PRELIMINARY/FINAL DRAINAGE REPORT

JUDGE ORR ROAD RV PARK & STORAGE DEVELOPMENT

**ADP Project No.160301
February 15, 2019**

PCD Project #PPR-16-040

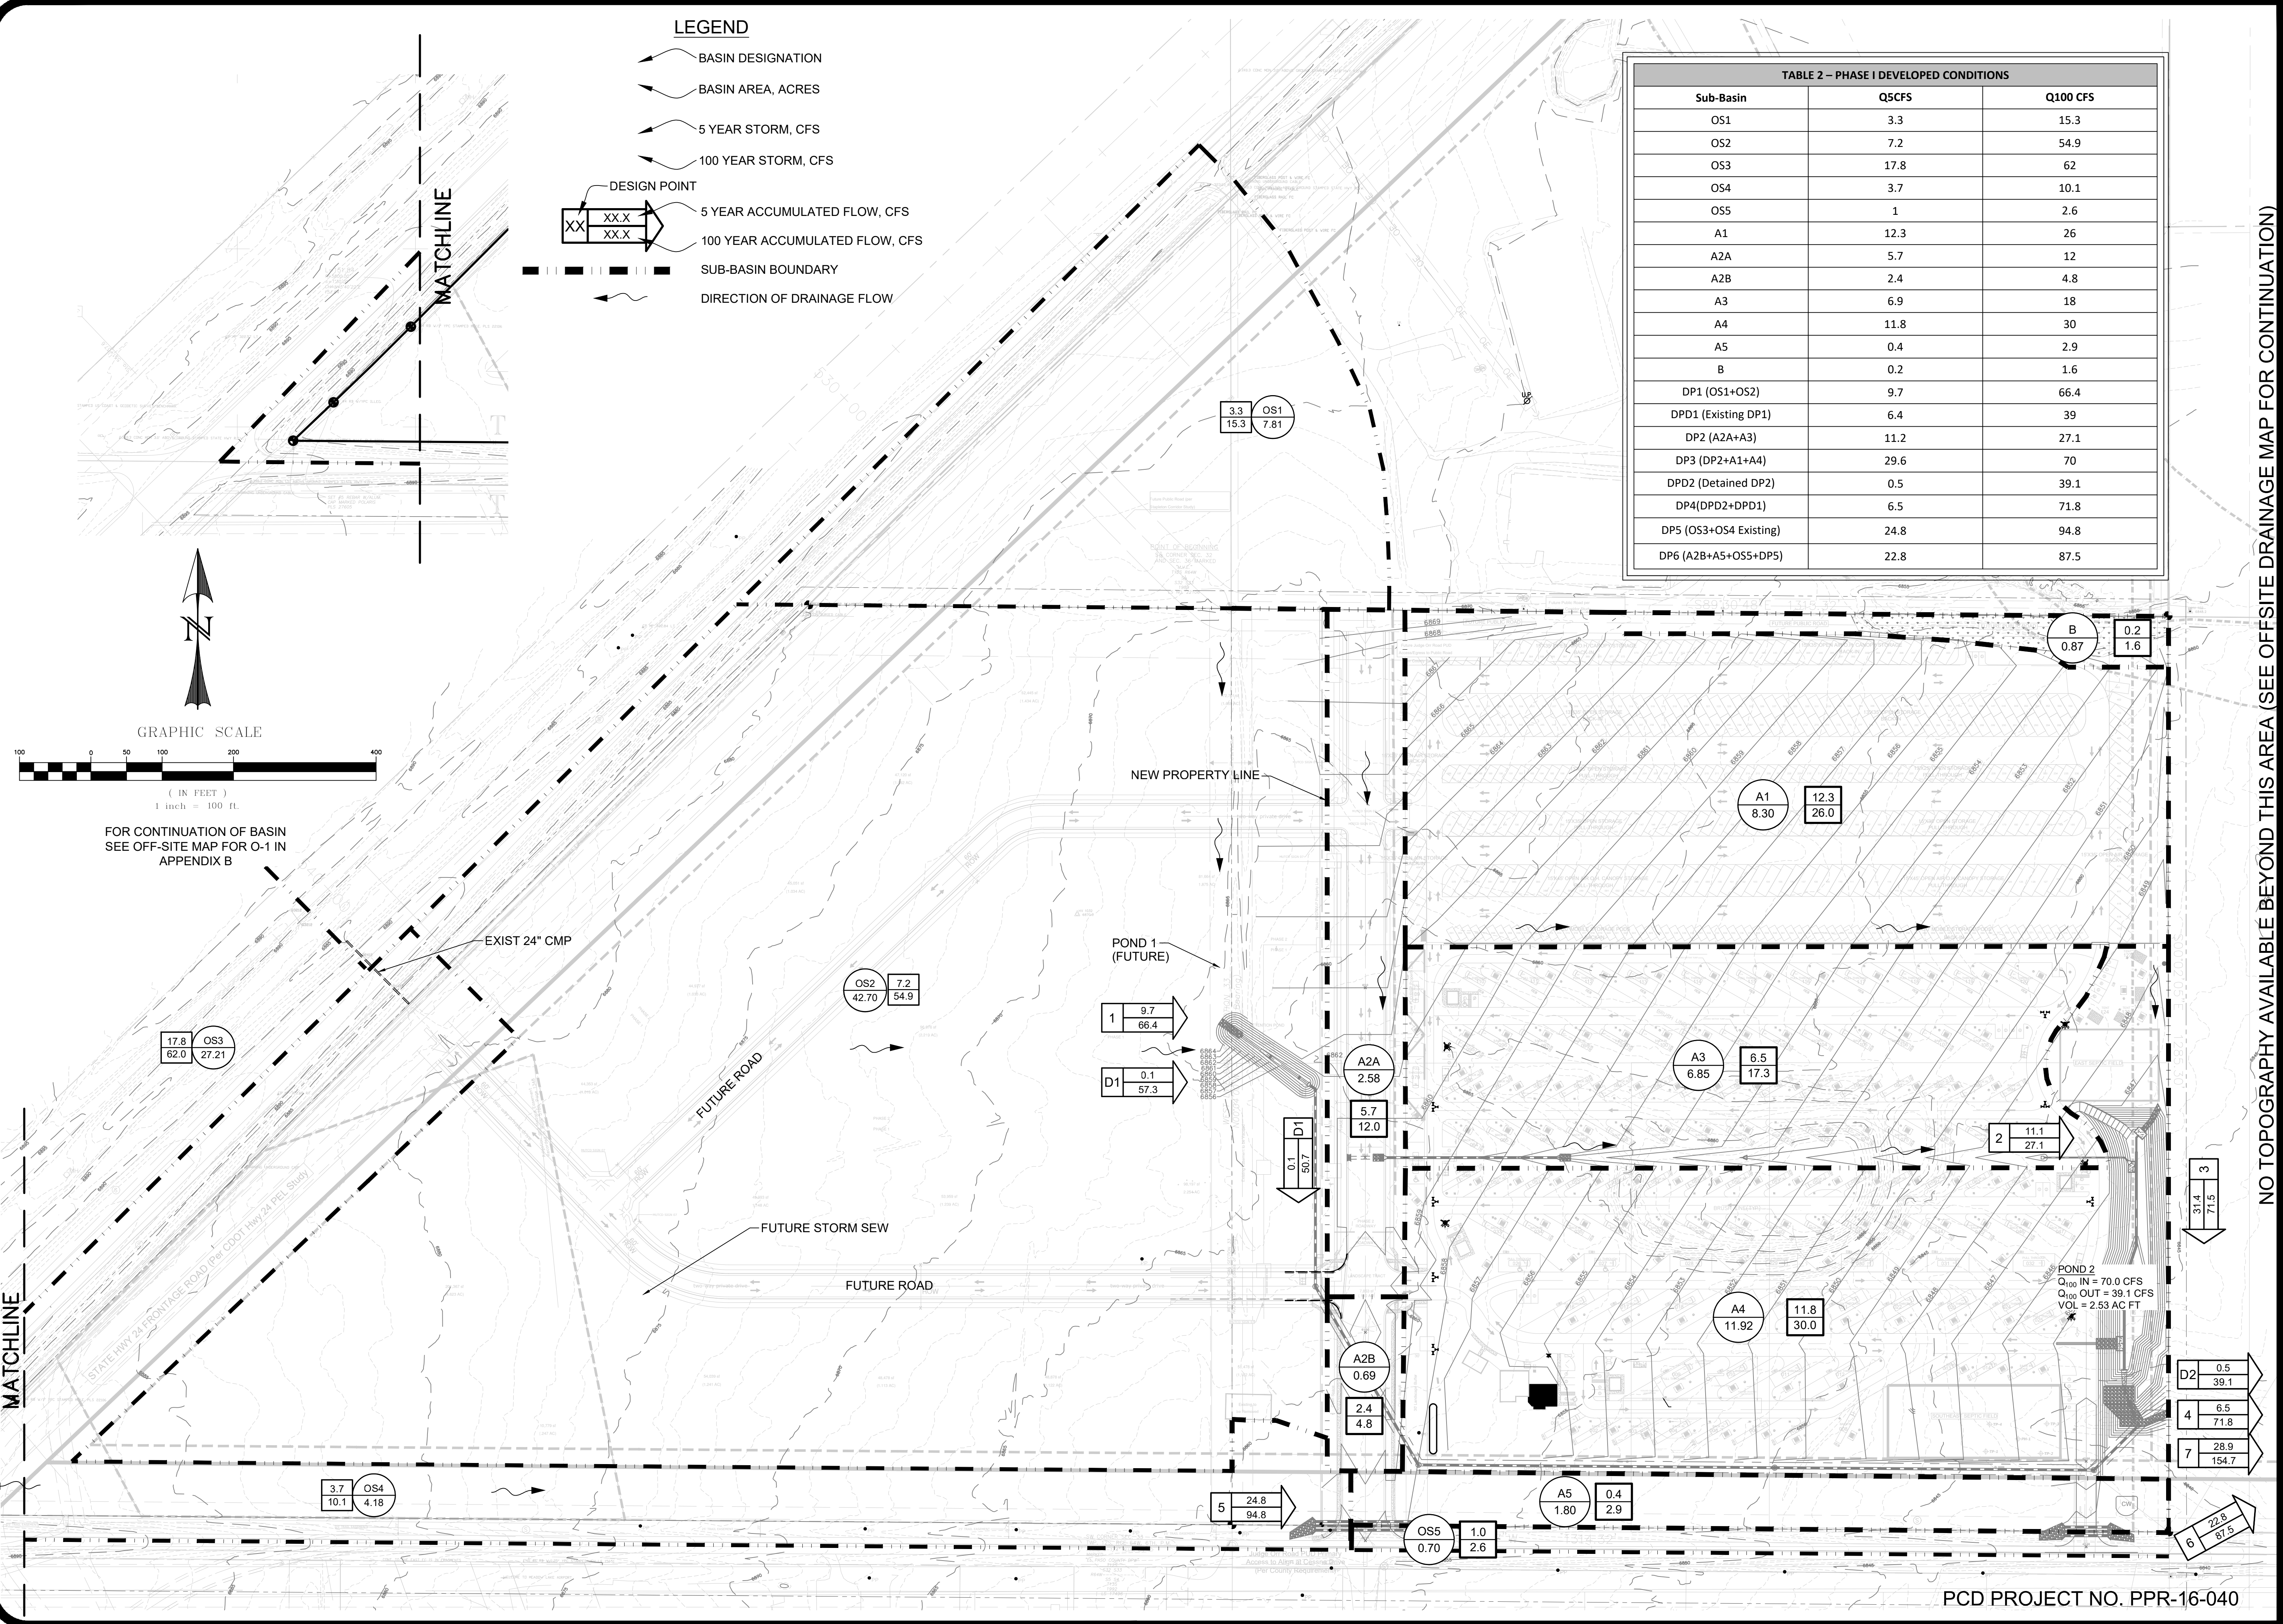
Revise to 30" if this is the same storm system discussed on the previous sentence.

Consider revising the storm sewer crossing the road to an RCP pipe if the intent is to eventually dedicate the road to the County for ownership and maintenance when the future development to the east occurs.

Alternative would be to identify in the narrative that the pipe will have to be removed replaced by the developer prior to dedicating the roadway to the County.

(ECM Chapter 3, Section 3.3.1.J.1 - All storm sewers within the County's right-of-way are required to be RCP min Class 3, Wall B)
